**Consultation Response from Mike Hibbert,
KC Waste Strategy(Refuse & Recycling)**

2023/93503 Land off, Roslyn Avenue, Netherton, Huddersfield, HD4 7EW

Outline application for residential development of 82 dwelling and associated works, with layout and access as considerations

Responding Ref: WPS 23-073

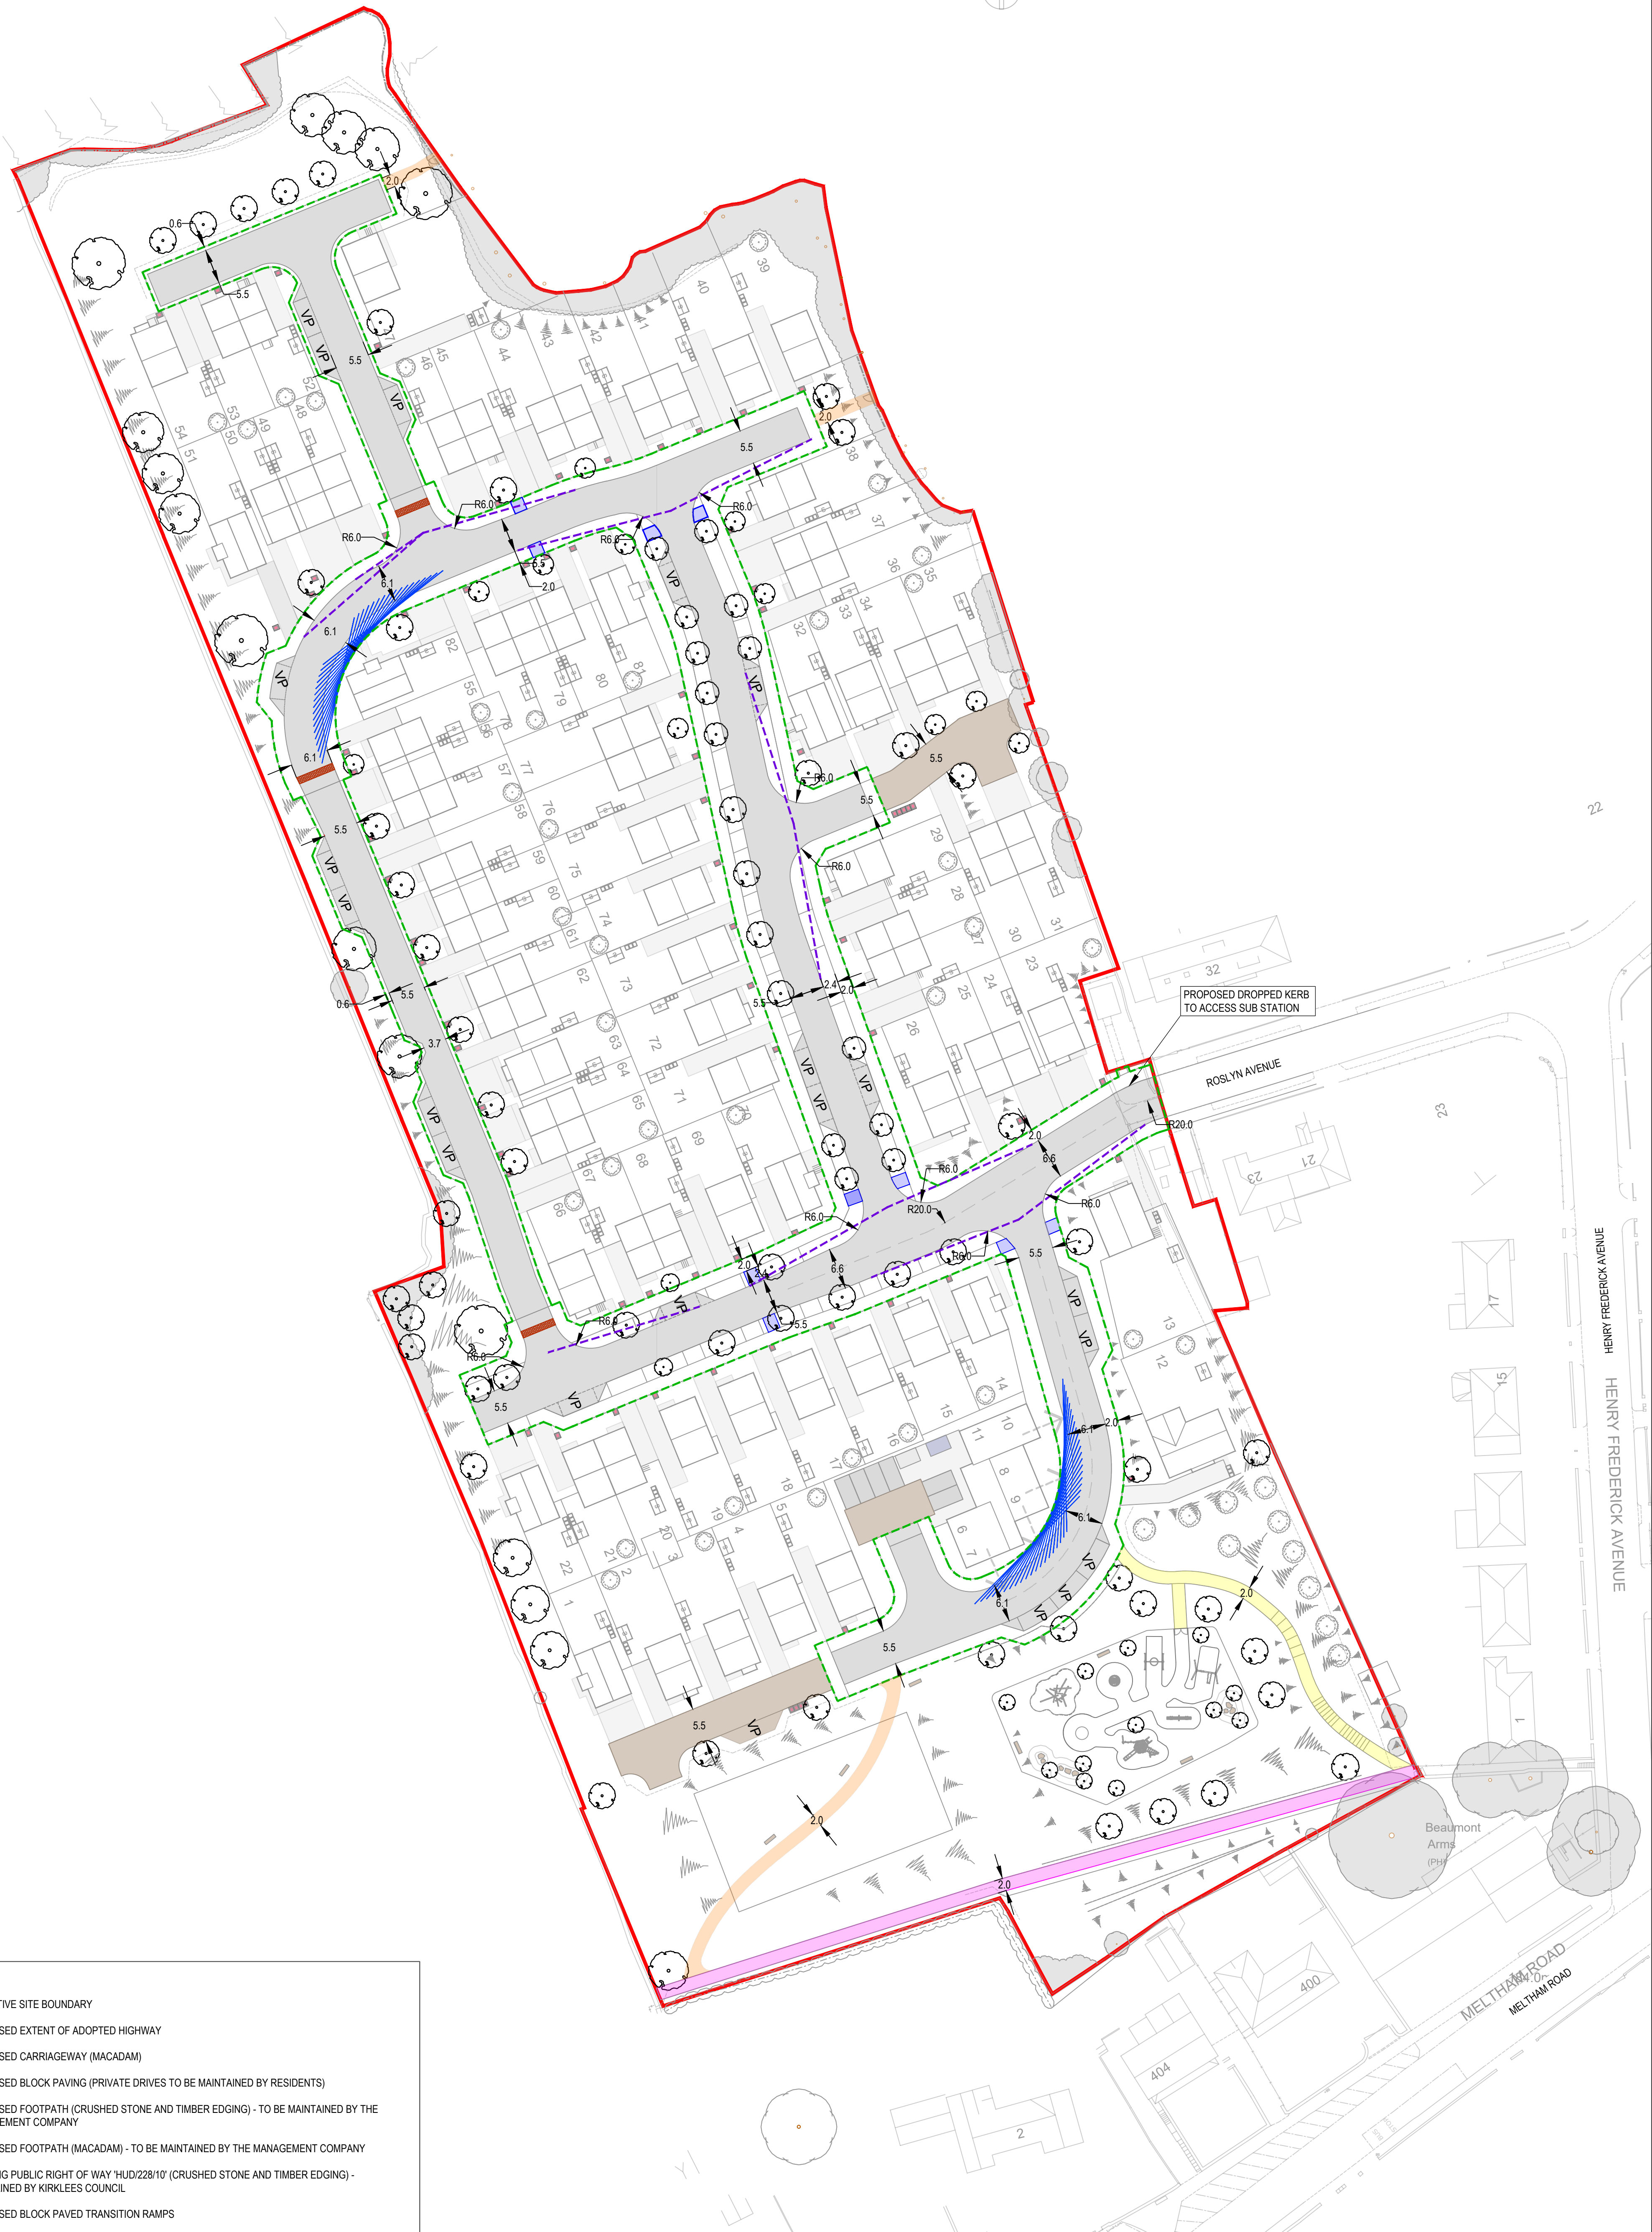
The plan Ref 2246 PL 105 dated November 2023 shows the proposed layout of the site. The plan is annotated with black rectangular icons to indicate bin stores for three wheeliebins on each plot and location of Bin Collection Points (BCP's) are shown with pink icons.

- It is welcomed that bin stores are in rear gardens to avoid impact on the Streetscene. For plots where bin storage is in the rear gardens with gated access that should be shown to be secure and gates wide enough to pass through. Clarification is sought about access to the rear gardens of Plots 12 and 13 as residents must not require residents to pull bins up/down steps or gradients of more than 1:12.

- It is not clear from the plan how residents of Plots 49, 59 and 79 will get bins from the rear gardens to presentation points adjacent to the highway. If storage in the rear gardens is not possible storage to the front of dwellings would be acceptable, but bins should not be located under windows/ next to doors. Wheeliebins located at the front of properties will be set within the Streetscene and therefore should be screened and secured to prevent bin blight, the spread of waste into the street, unauthorised use and theft/damage to bins.

- For six one-bedroom apartments the recommended waste storage provision is approximately 600 to 1080 ltrs for both residual and recycling bins. Appropriate waste

- The Authority will not take an RCV into private drives or roads that are not built to adoptable standards. Confirmation is sought that the road in front of Plots 55 – 66 is to be adopted.
